7 December 2022

Our Ref: SF22/3686
Our Contact: Matthew Hammond (02) 9562 1621

RE: Request for Advice – Environmental Impact Statement – Multi-Level Warehouse, 1-3 Burrows Road, St Peters [SSD-35962232]

Figure 14 Viewpoint location map

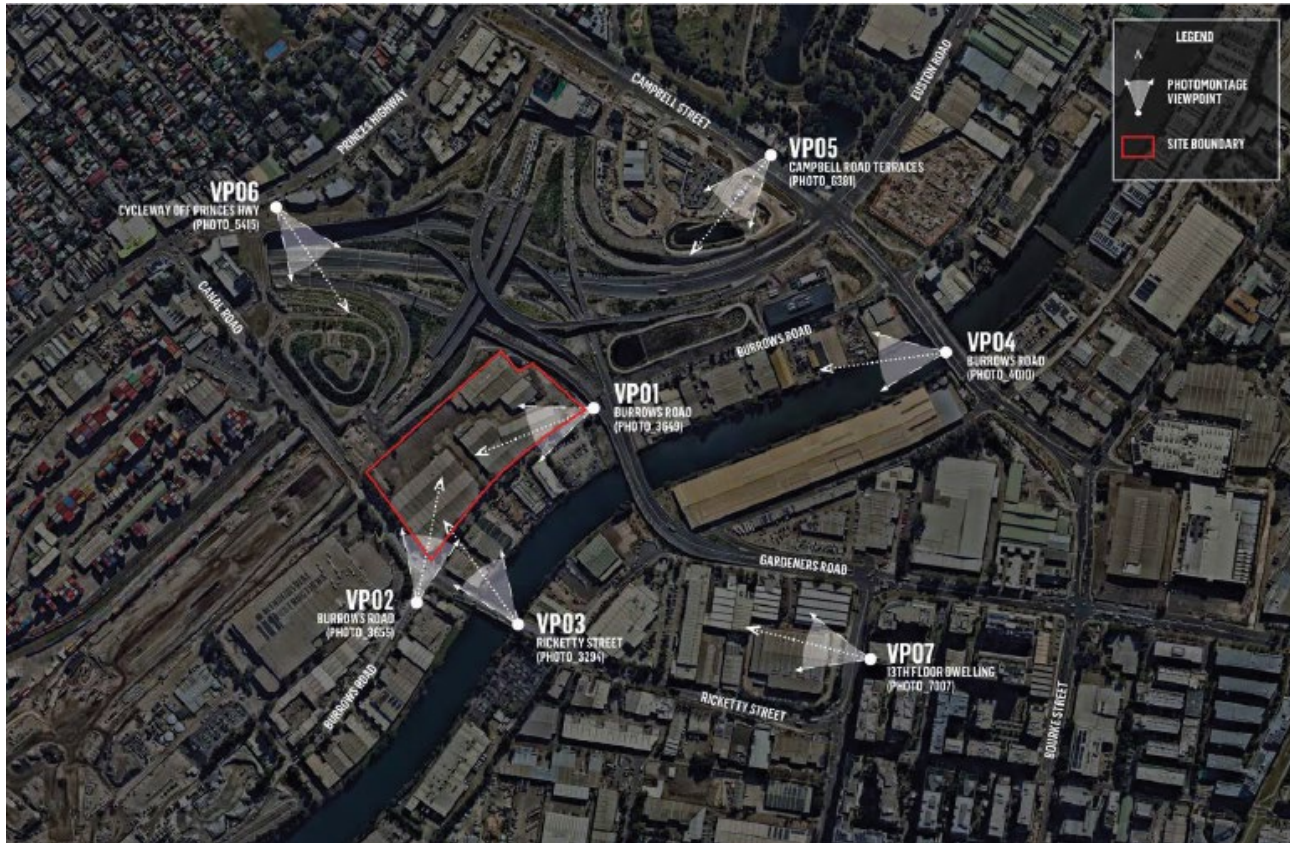
Council officers raise concern with the visual appearance of open vehicular ramps, which may appear unsightly when entering the Bayside LGA along Canal Road. *View 04* within the *Visual Impact Statement* (VIA, Appendix N) illustrates this viewpoint. Within the project response of Appendix D of the EIS, it is stated that several species capable of growing approximately 30m high will be included within the landscape setback. However, the

It is noted that the visual impact of the 210m wide and 25m high façade along Burrows Road is intended to be broken up through use of three materials along three equal bands, and a 6m wide setback. Given the wide façade, Council notes that *View 03* of the *VIA* is unable to demonstrate the full view of the proposed development. An image highlighting the full extent should be included to demonstrate the visual impact of the development more accurately. Furthermore, Council officers request two additional viewpoints to the *VIA*, listed below:

1. Views looking west from Gardeners Road, near the Kent Road intersection, are listed in the *VIA* as having high visibility of the proposed development. This location is also the boundary of the high-density Mascot precinct; and
2. Views from the foreshore of the Alexandra Canal from the Bayside border. The Alexandra Canal, including the sandstone embarkment, is classified as a State heritage item (1260) under the *Bayside Local Environmental Plan 2021*. This area may become a future pedestrian area as Coward Street and the broader Mascot precinct becomes increasingly promoted as a 'place for people', becoming a walking and cycling friendly area (embedded in the District and Local strategic planning policy framework).

Figure 20 Tree retention and removal plan

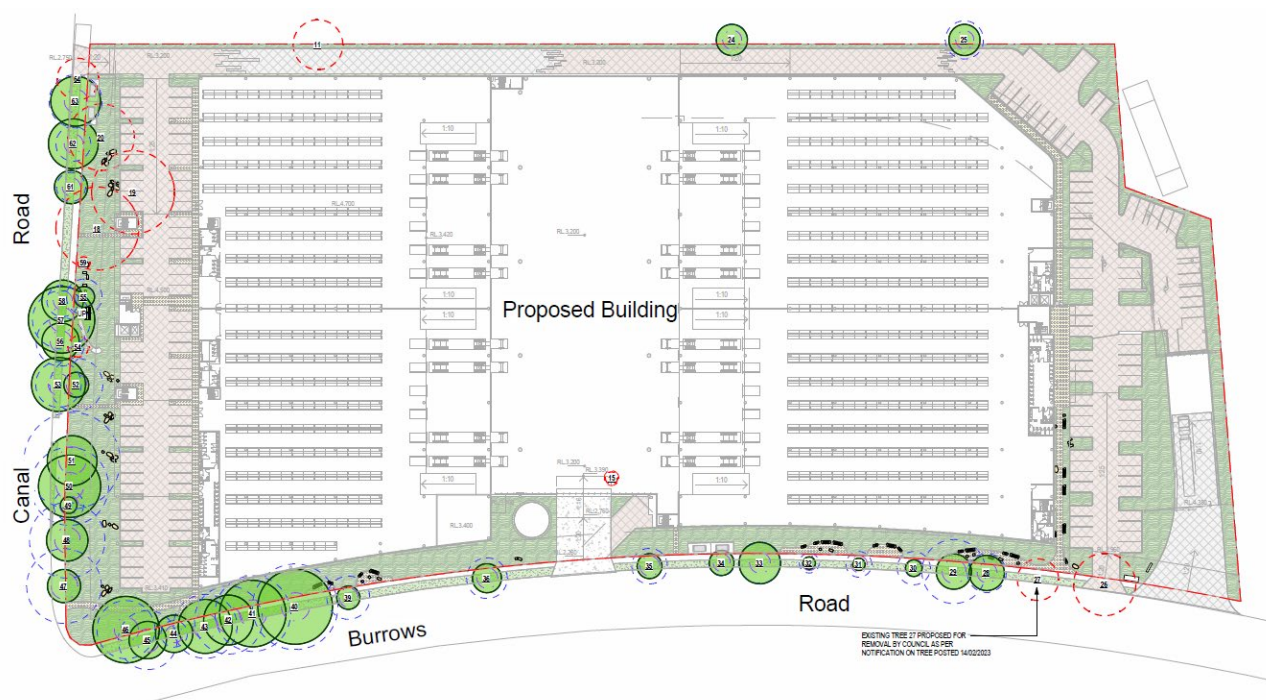
Landscape Plans (Appendix P) describe the tallest trees as being capable of growing to 20m height, occurring in only two species. The *AIA* (Appendix Q) identifies three trees on site that are capable of 30m growth, however two of which are planned for removal. Due to the removal of large trees, Council's Landscape Architect noted that some renderings included within the EIS have exaggerated the size of retained trees, recommending that proper scale be included for a more accurate representation.

Council's Landscape Architect also raised concern that the close proximity to the building will limit the future possible maturation of tree species within the 6 metre setback. Further, almost all retained trees are currently planned to have footpaths and/or roads encroaching their Structural Root Zone (SRZ) and Tree Protection Zone (TPZ). Council recommends further mitigation measures to ensure proper care of new and existing trees as advised within the *AIA*, permitting adequate space for mulching and care requirements in the SPZ and TPZ of all trees during the construction and operation stages of the proposed development.

Figure 11 Concept Programable Art

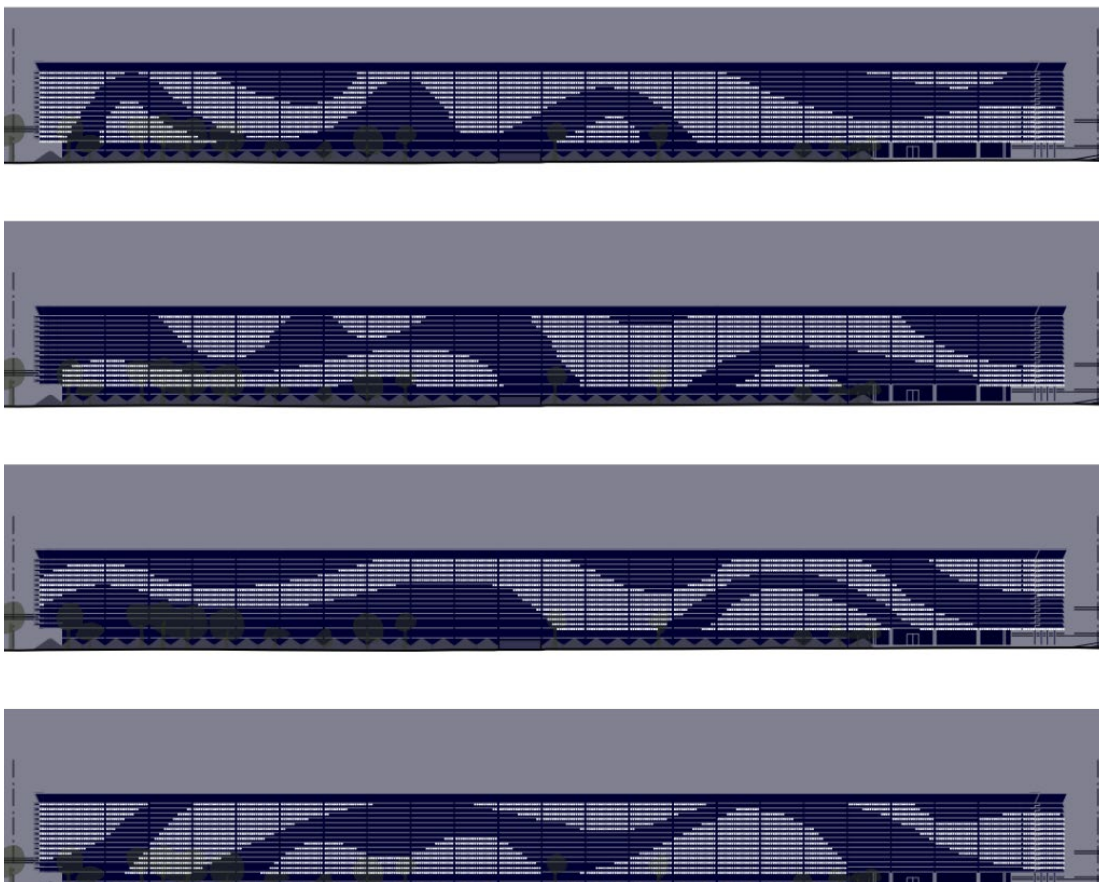
It is noted that programmable light art is intended to be utilised to reflect the concepts of change and movement, and create a visually appealing canvas. Additional renderings should be presented demonstrating the possible visual impact this may have on Bayside residents at night.
